From: Martyn White <Martyn.White@arun.gov.uk>
Sent: 14 August 2020 17:38
To: Amy Myer <Amy.Myer@arun.gov.uk>
Subject: LU/163/20/PL

LU/163/20/PL

6 Selborne Place, Selborne Road, Littlehampton BN17 5NH

Demolition of existing conservatory, single storey front & rear extensions & change of use from HMO (Sui Generis) to 5 No. flats (4 net) (C3 Dwelling house).

Proposed Second Floor Plan 1:50

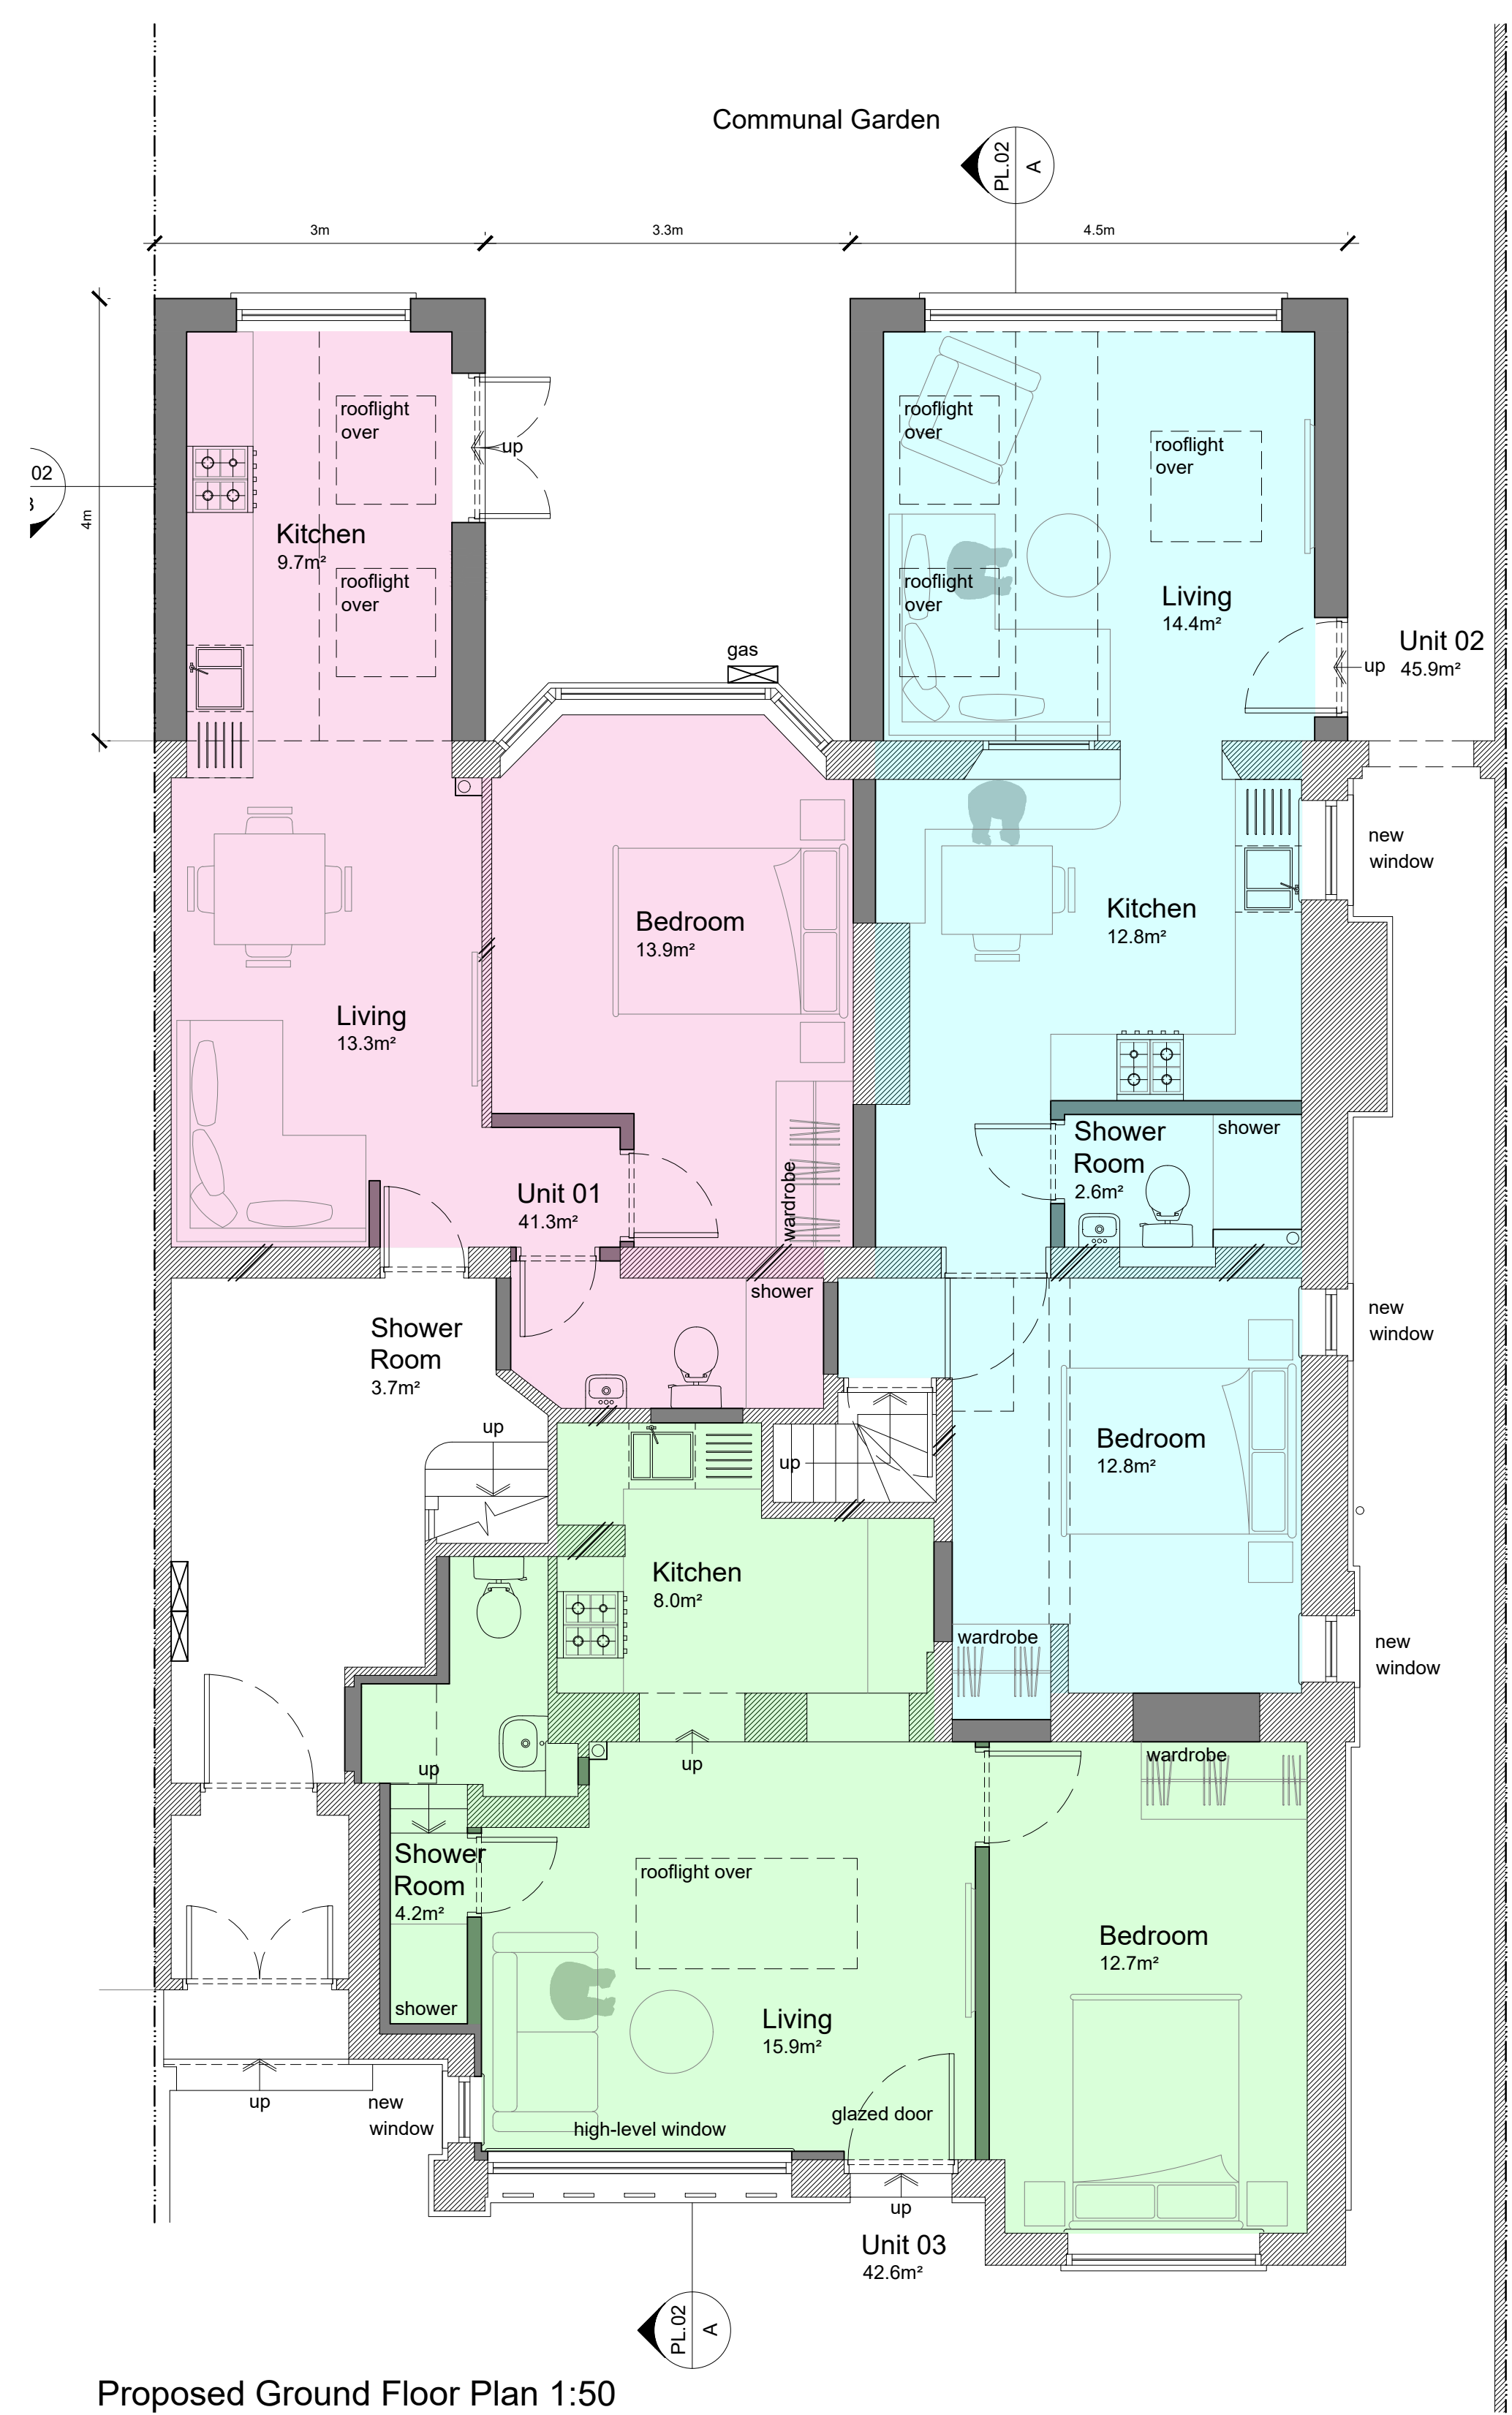
The proposed front extension will not be a prominent addition due to the fact that it is utilising the exiting courtyard area. Whilst the loss of the modern conservatory is a positive feature of the proposal, the new extensions will be more prominent, which will interfere with the original rear elevation of the building. This is unfortunate, and harmful. It is also suggested that proposals such as this should look for opportunities to enhance or better reveal their significance i.e. the use of more appropriate joinery; it is not clear if that is the case here.

The retention of the existing honeycomb detailing as part of the front extension is positive, and supported. Details of how the existing clay honeycomb walling will be kept and preserved as part of the creation of the north extension should also be considered so that they are not harmed.

Proposed Front Elevation (N) 1:100

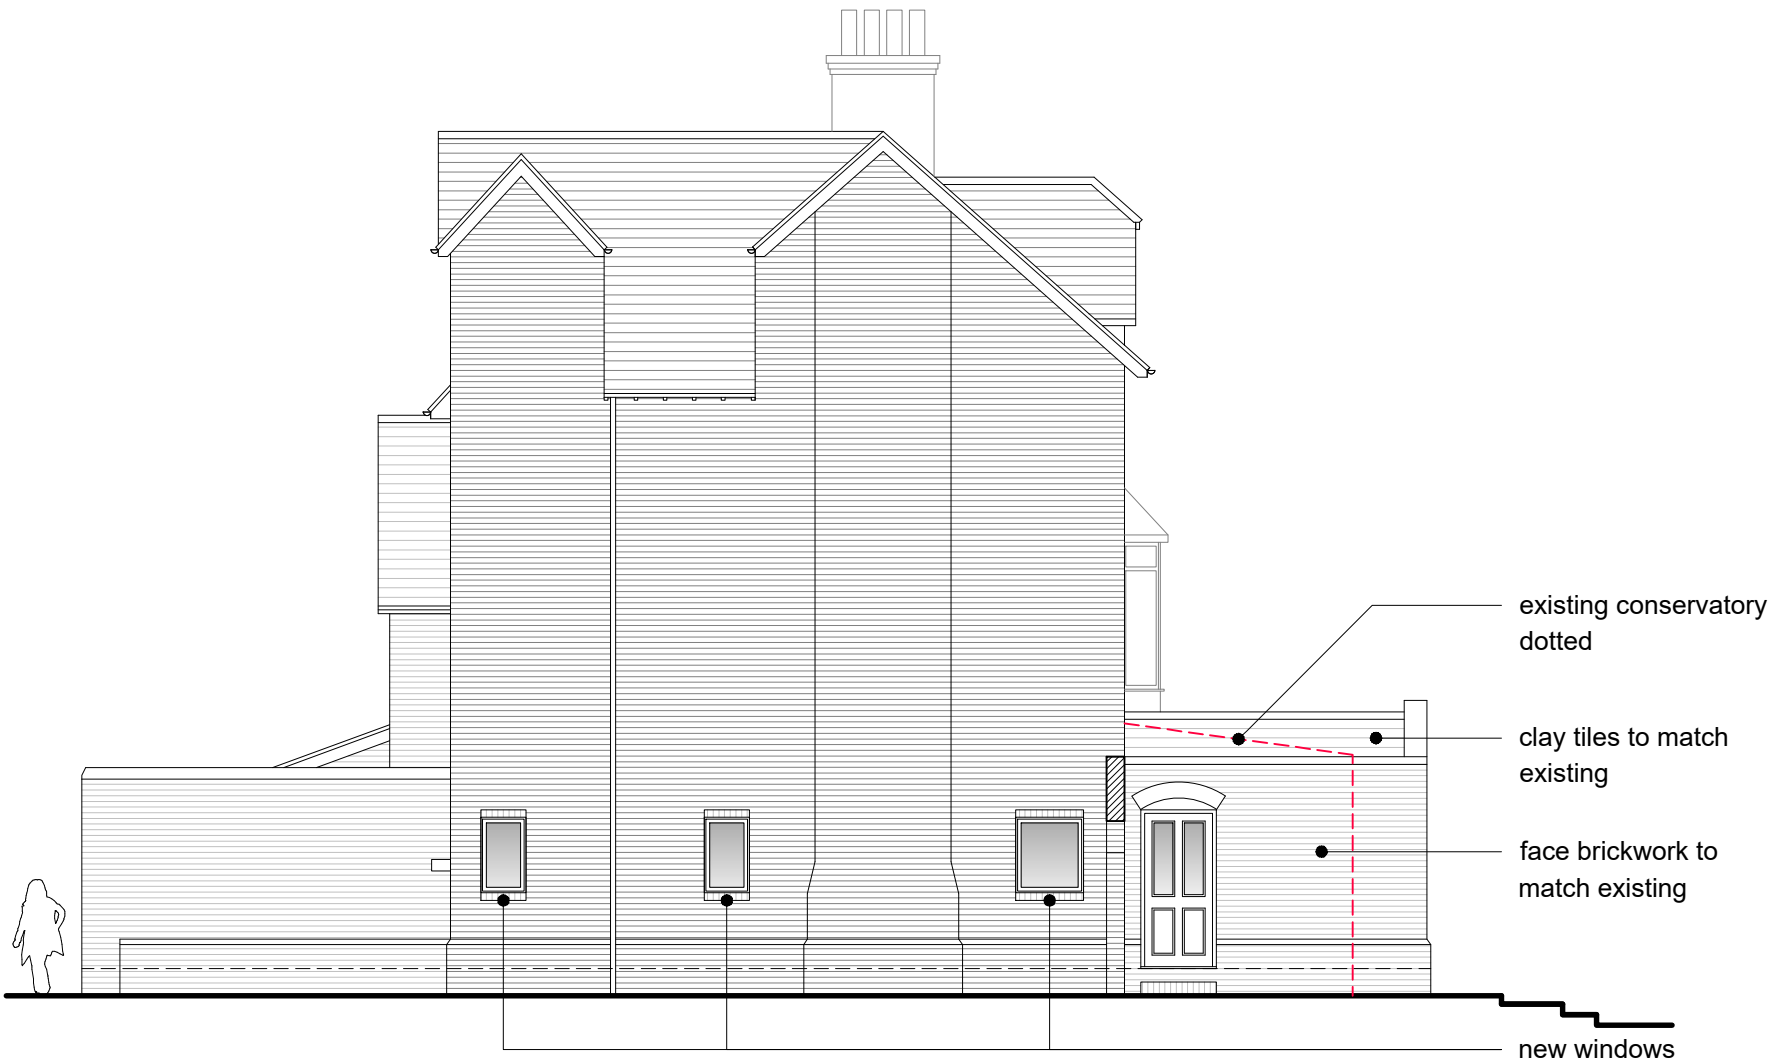
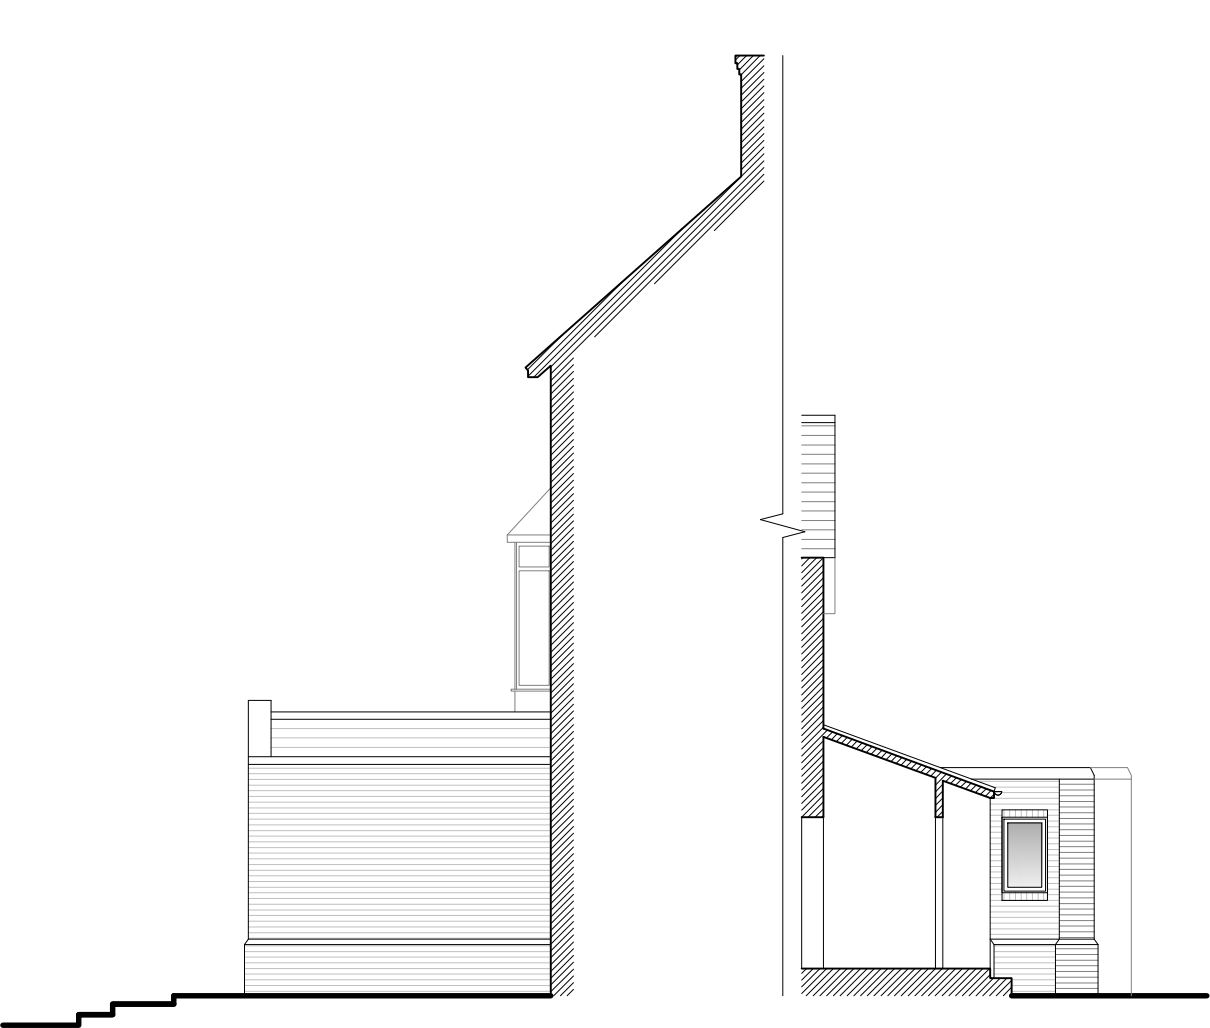
The elements of Gothic design and clay honeycomb walling are considered to be important in the context of both the property and the wider conservation area, and they should be retained as part of the proposal.
